From: Sue Howell <Sue.Howell@arun.gov.uk>
Sent: 06 November 2019 14:13
To: Planning.Responses <Planning.Responses@arun.gov.uk>
Cc: Michael Eastham <Michael.Eastham@arun.gov.uk>
Subject: RE: Planning Consultation on WA/95/19/DOC

Further comment from Greenspace

APPLICATION NO: WA/95/19/DOC

Description of Works: Approval of details reserved by condition imposed under ref
WA/95/18/RES relating to Condition No 5 - golf mitigation

Project	Land East of Tye Lane, Walberton		
Title	Golf Course Netting Indicative Detail		
Client	Linden Homes		
Scale	1:100 @ A3	Drawn	AL
Date	Sept 2019	Checked	GC
Drawing No.	CSA/3823/119	Rev	B

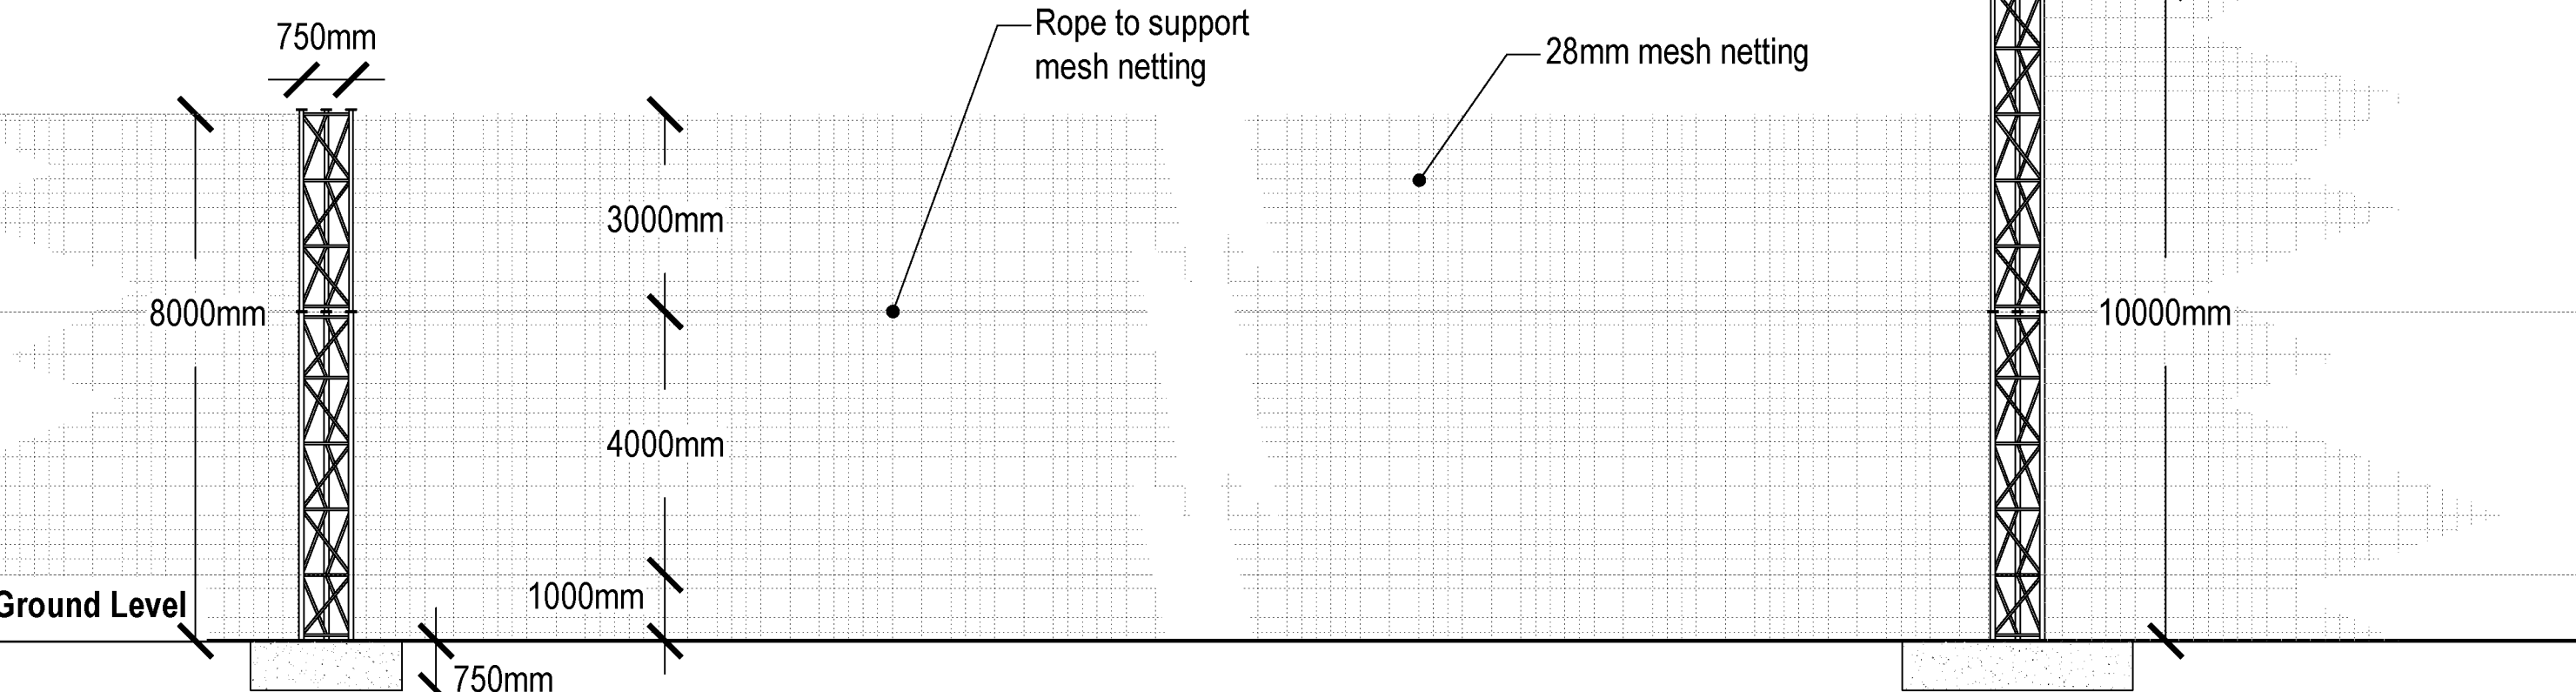
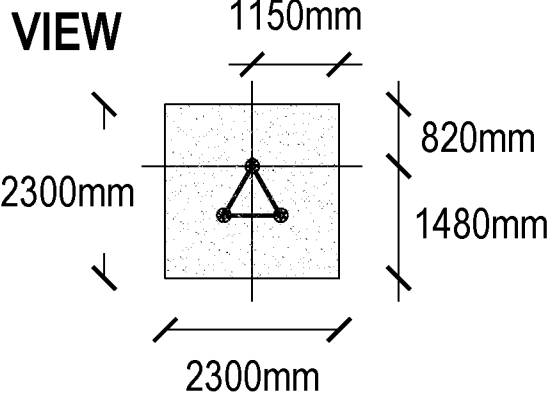
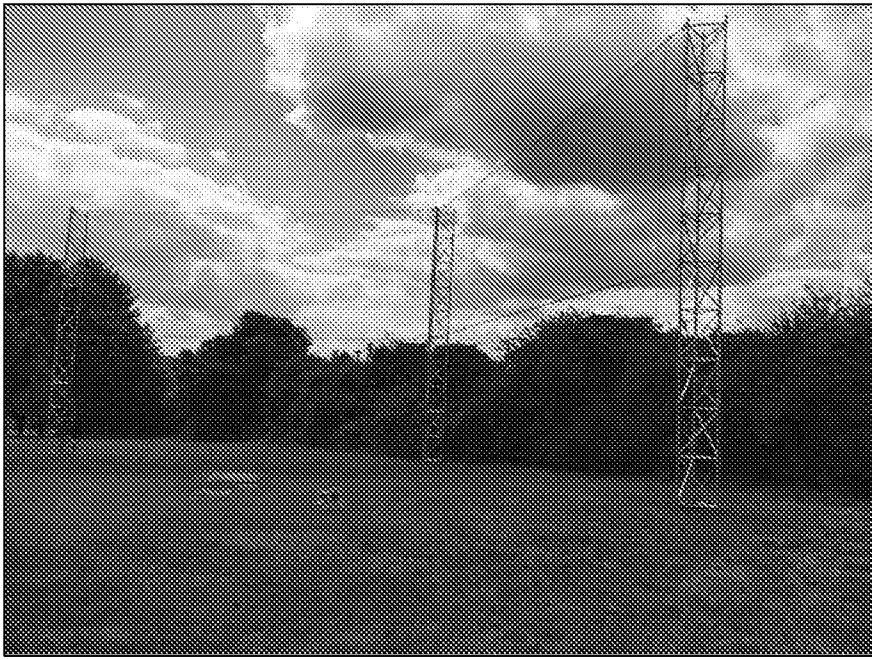
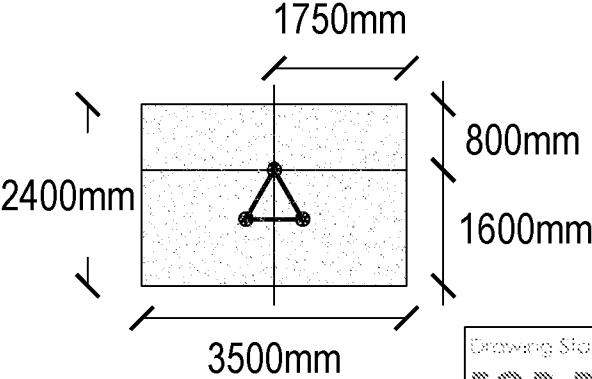
Further to submission of Landscape revision specifically re Golf Course Netting Details and now contained in Dwg Sept 19 GNL.01 Rev B Proposed Golf netting Location now staggered and location amended and CSA/3823/119 and associated Soft landscape proposals dwgs CSA/3823 101-103 CSA/2823/107-110 I can confirm that the information supplied proposes a scheme for the purpose of offsetting any on-site or offsite mitigation measures to minimise the ingress of golf balls onto the site, along with a landscape proposal which over time should minimise the visual impact of these measures.

The detail of the ball stop netting adjacent to the golf course, has a planting proposal which whilst would not disguise it, will go somewhere over time to softening the impact of this –however not to the full height 10m of the fencing proposed. I confirm that I would see an visual improvement in the staggering of the fencing now 6-10 metres The visual impact of these measures along this boundary should be noted. There has been the inclusion of mature tree planting in this location which has a greater opportunity as it establishes to detract the eye, whilst allowing important views through to the golf course beyond.

The fencing will need to be maintained in good condition thereafter in order for the purpose of this to be realised.
